Marine Management Organisation

MMO Reference: DCO/2021/00002
Planning Inspectorate Reference: EN010119
Identification Number: 20051047

Planning Act 2008, Proposed North Falls Offshore Wind Farm Project Order Deadline 4 Submission

This document comprises the MMO's submission for Deadline 4.

Plate 1.2 Proposed piling mitigation procedures.

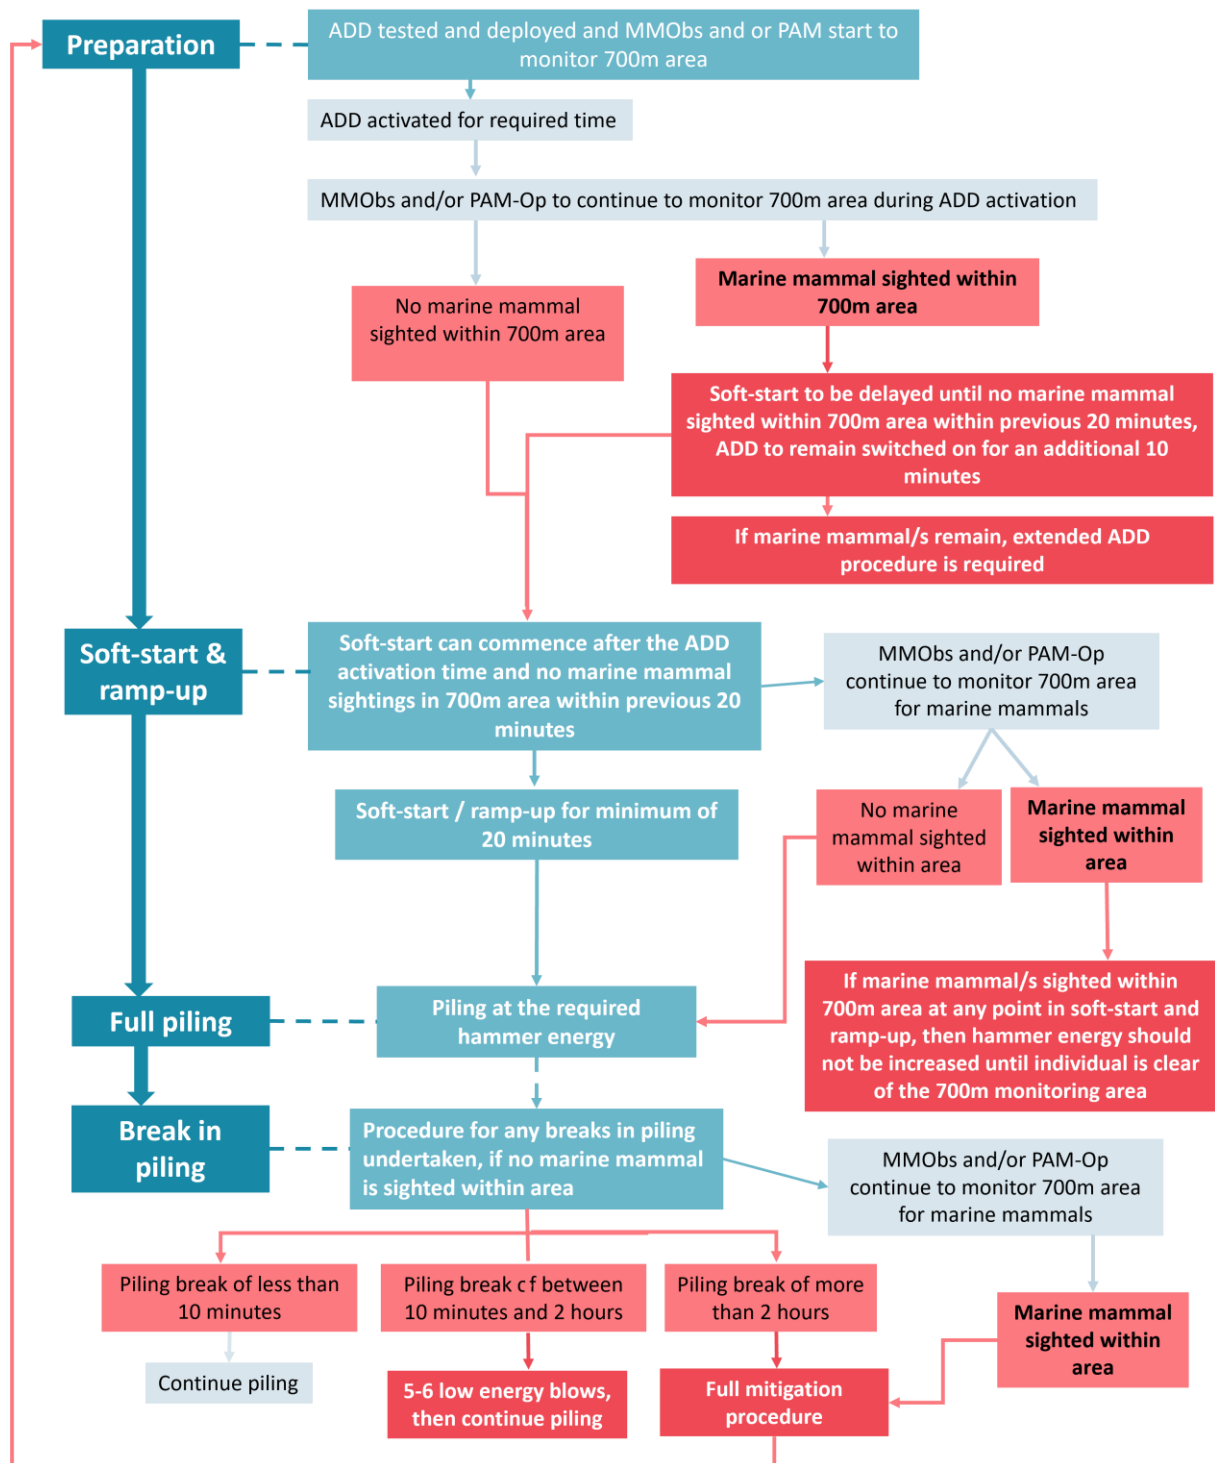
- 4.2.6 The MMO welcomes that Plate 1.2 has been amended to indicate monitoring by Marine Mammal Observers (MMObs) and/or Passive Acoustic Monitoring (PAM) operators must be continued throughout breaks in piling.
